RE: 5401 Fountain Valley School Road
Stealth Wireless Telecommunications Facility
(Verizon Wireless: CSP BIG JOHNSON)

Please accept this as a letter outlining how each comment was addressed as part of the resubmittal for the above referenced project.

Drawing Revisions (Rev. F, dated 8/20/19):

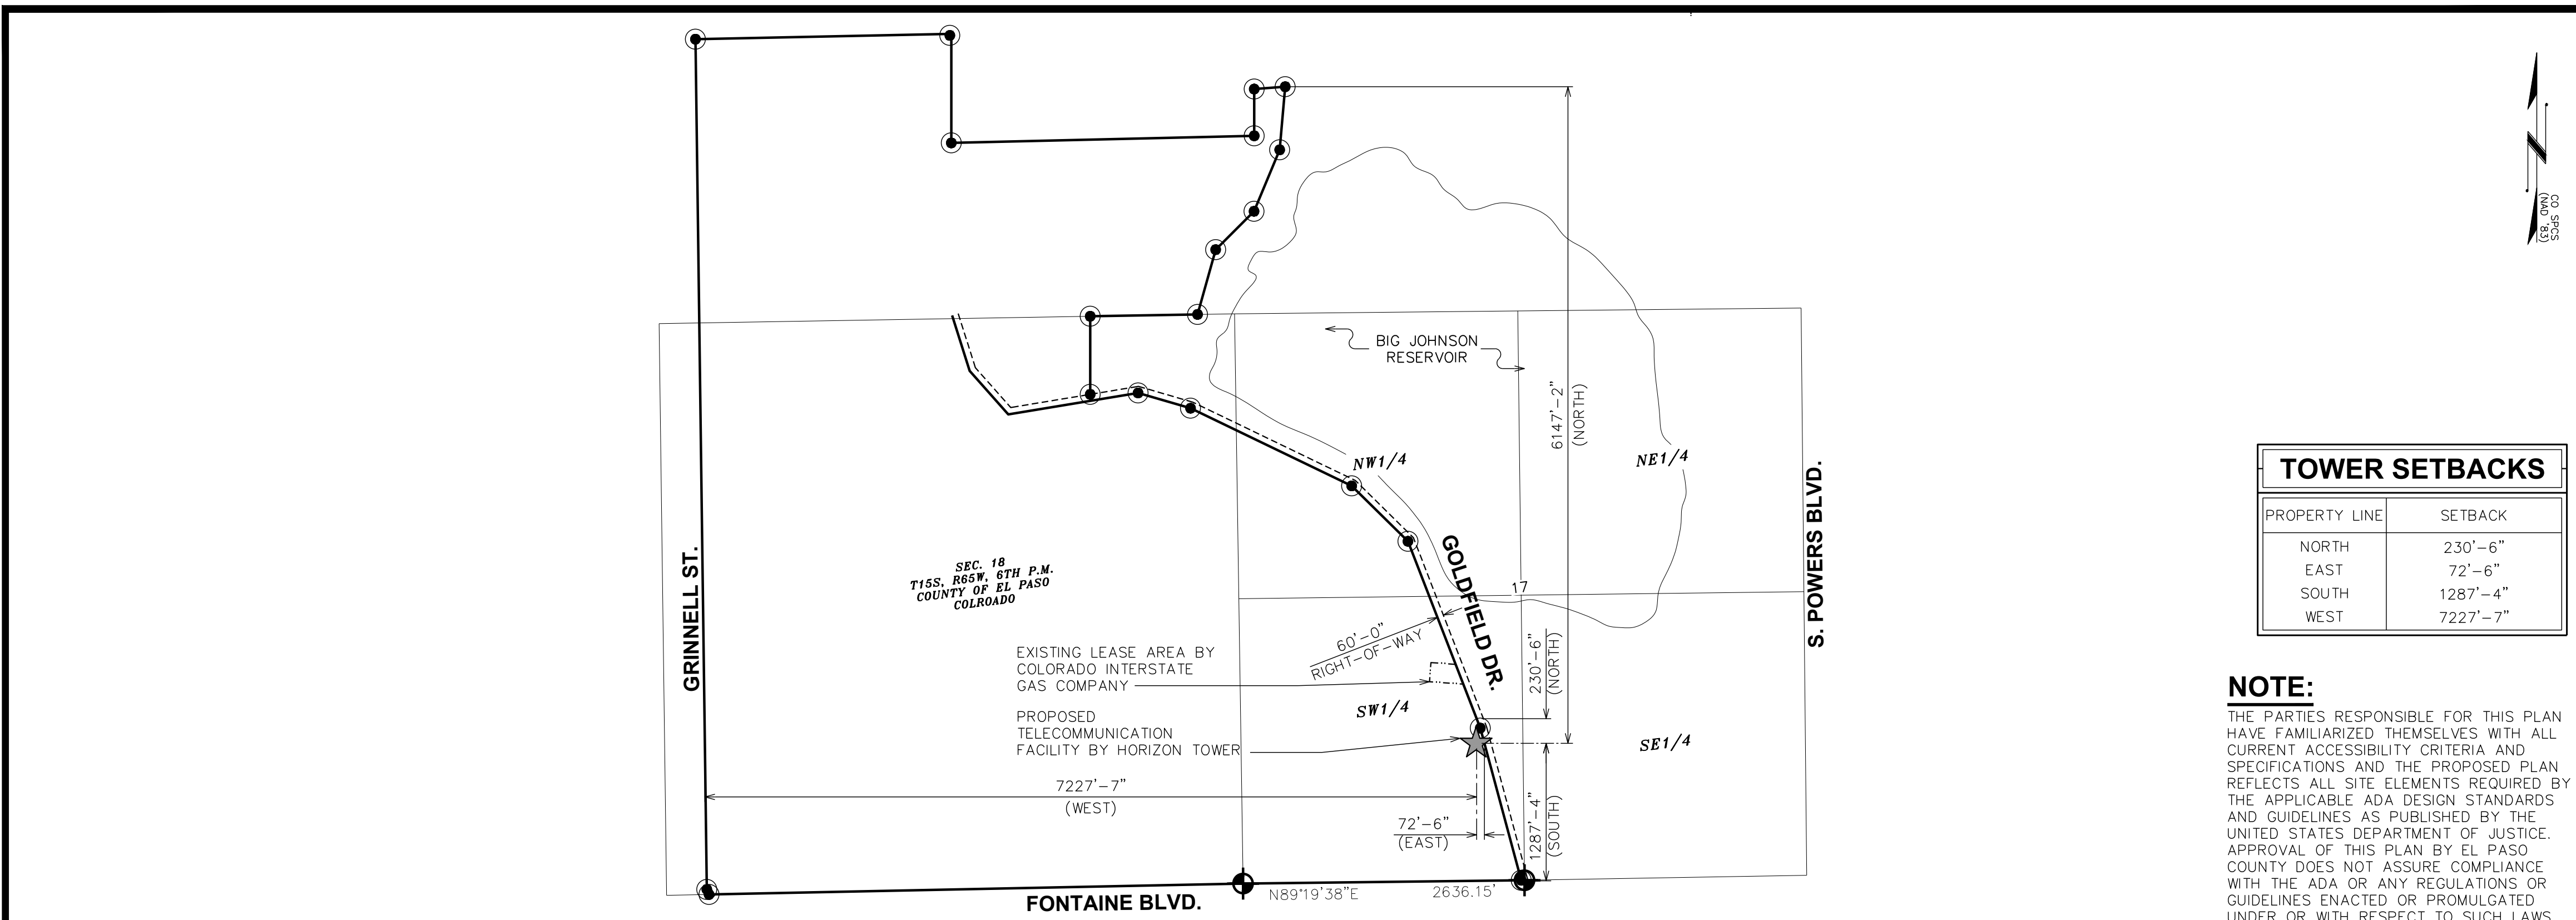
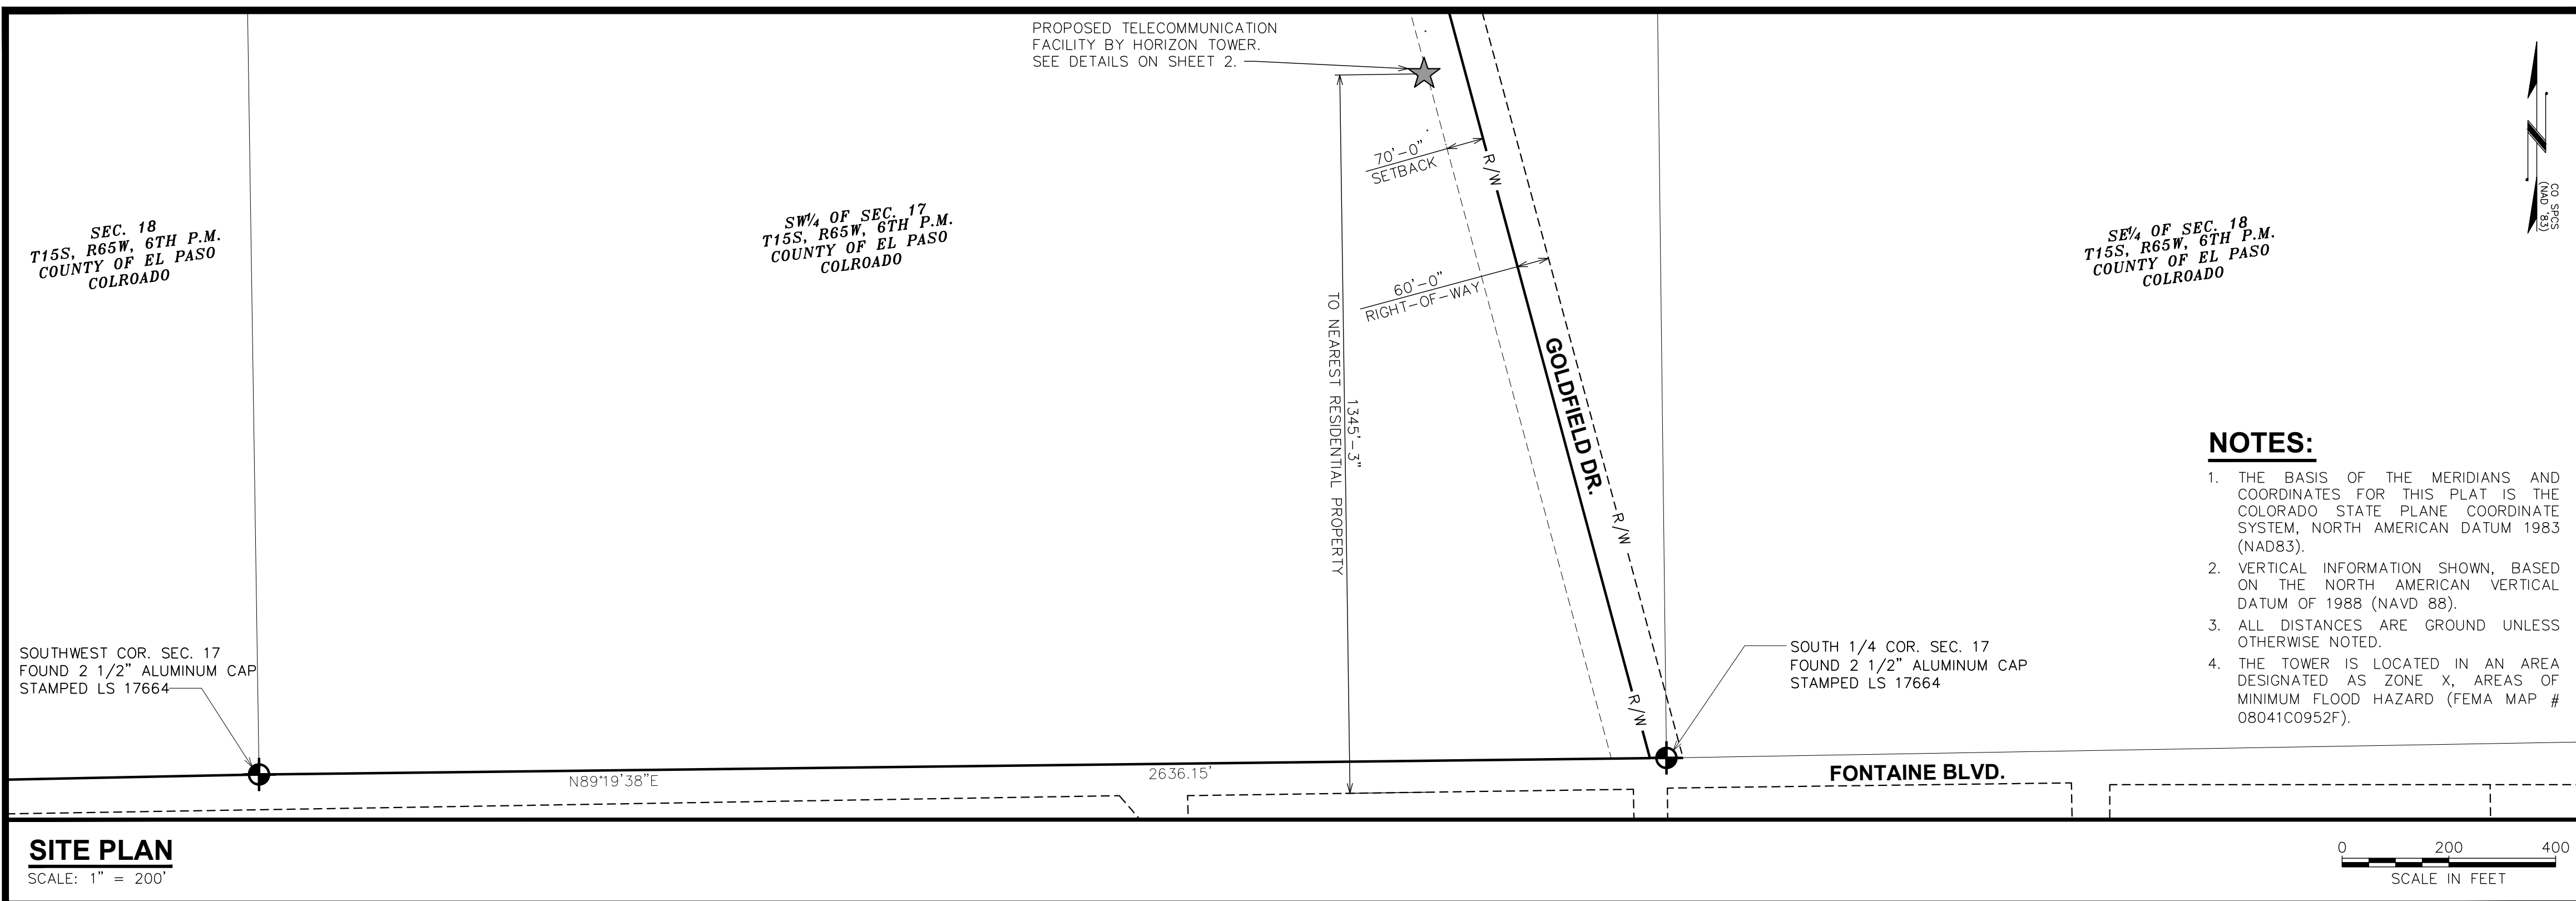
- Cover Sheet: Area Map revised to show entire parent parcel with a table detailing tower for setbacks from property lines.
- Cover Sheet: Site Plan revised to show distance to nearest residential property.

Cover Sheet: Area Map revised to include note:
